Our Ref: BR/323/18/HH
Your Ref:

Town & Country Planning Act 1990 (as amended)
Town & country Planning (Development Management Procedure) (England) Order 2015
Application for Planning Permission for Works or Extension to a Dwelling

Development Two storey side extension to existing dwellings and internal alterations
Location 4 Parklands Avenue Bognor Regis

SITE PLAN 1:500

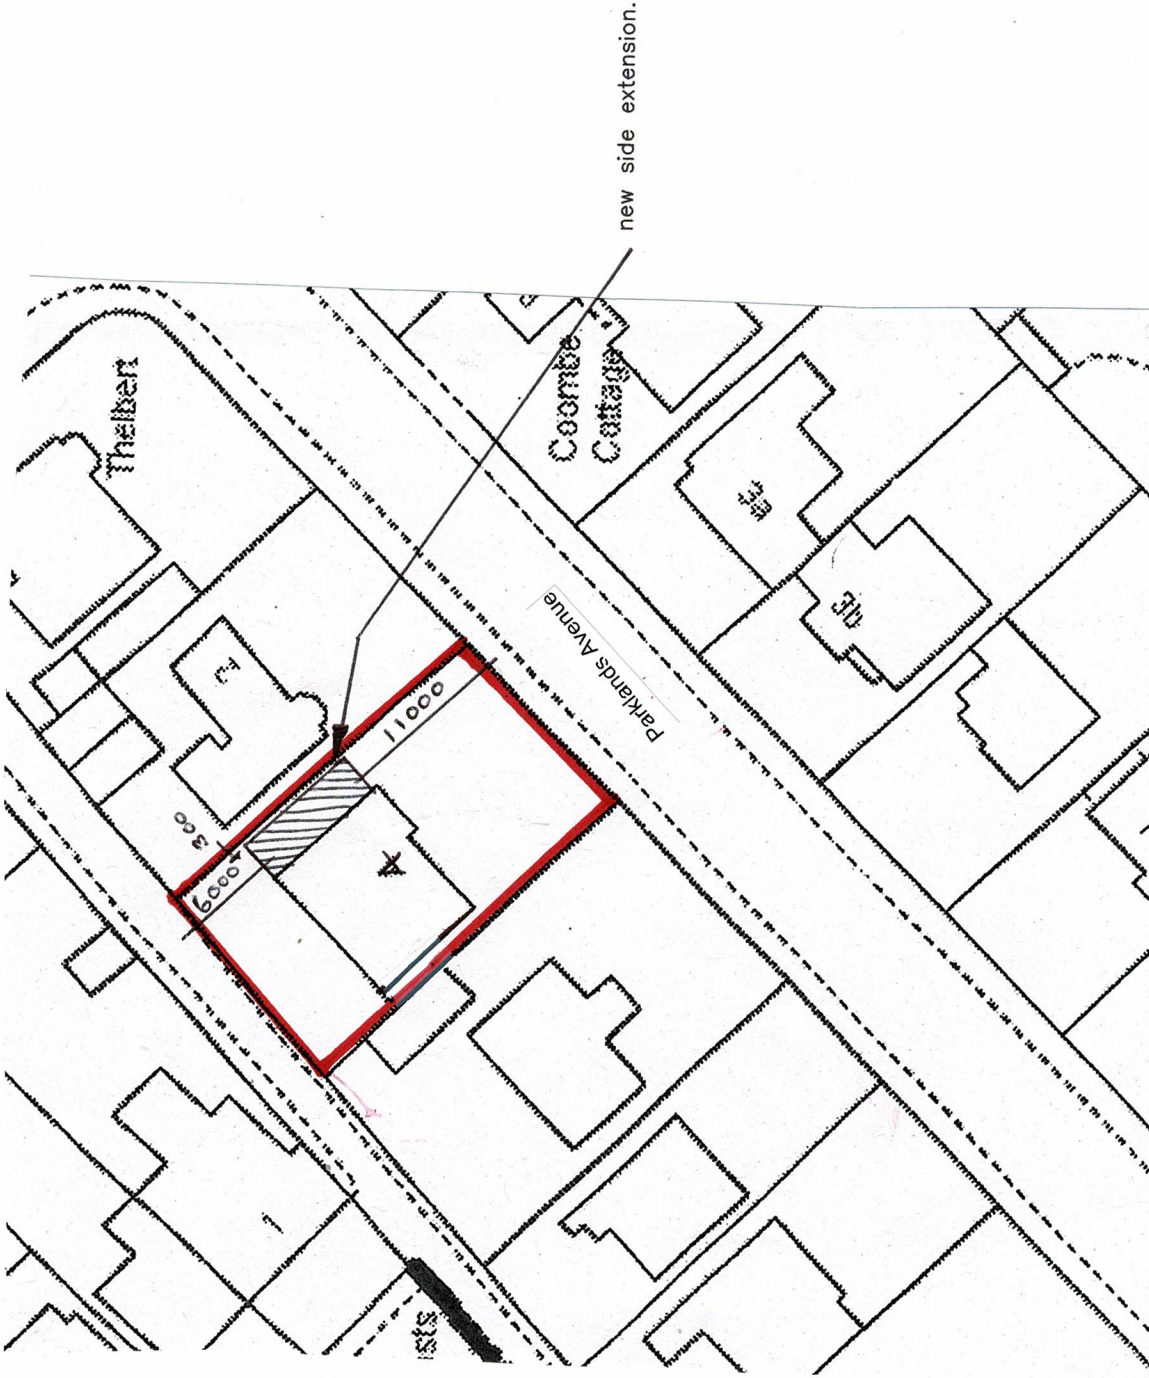
Block Plan: You are required to include a dimension from the side of the proposed extension to the side boundary on the block plan. Please amend accordingly.
